Planning Officer: Mr F Gardner
Planning Application Ref: **AW/187/19/T**
Location: **45 Craigweil Lane, Bognor Regis, West Sussex, PO21 4AN**
Description of works: **Dismantle and fell to ground level 1no. English oak tree**
Reasons Given: Obstruction to vehicles attempting use of driveway

T1 – English oak

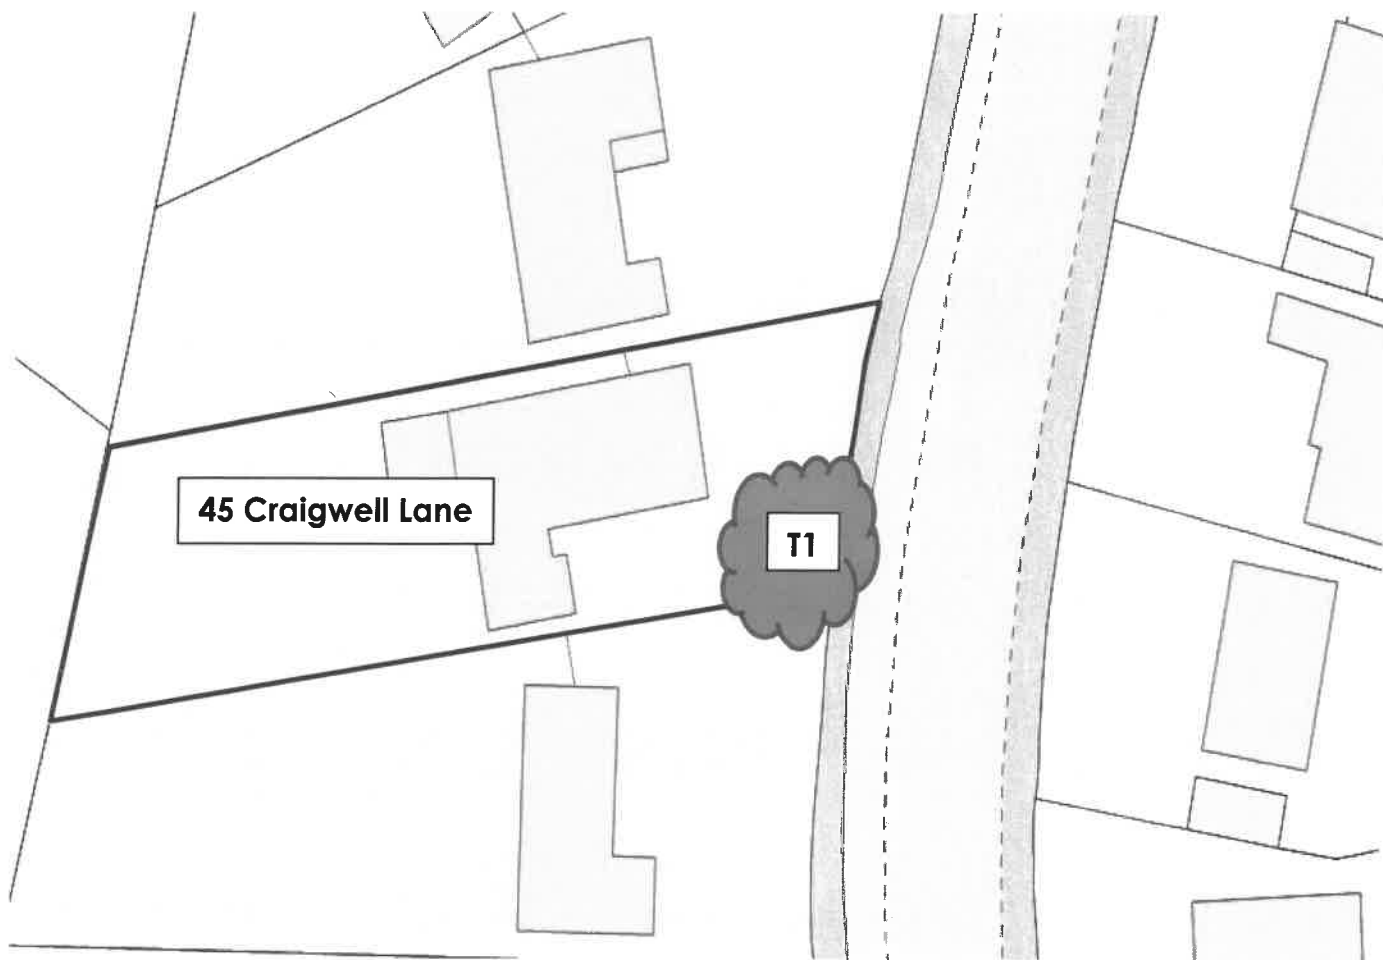
- Outwardly it appears to be in a fine physiological state and structurally sound. It is a prominent tree both highly visible from numerous properties and to users of the public highway (footway and carriageway).
- The upper limb and branch framework has achieved good symmetry and presents an attractive crown profile, albeit on an imperfect (pronounced kink) but nonetheless strong main stem.
- The property is served by a single vehicle width driveway to garage at the only logical position for this plot. The present obstruction from main stem prevents access across half width to between 2 and 3metres above ground level.

- The work proposed is justified on arboricultural grounds as the present situation is intolerable for the occupier(s) and there is no intermediate tree work option or reasonable engineering solution which would allow for harmonious retention of the tree.
- It is ecologically and aesthetically unfortunate to lose such a valuable tree, although there is a relatively high density of trees in the immediate locality with landscape value and long-term viability. In view of this and the absence of a suitable location for adequate replacement planting close enough to the original tree I would not look to condition the same in this instance.

- I recommend **CONSENT** for this application.
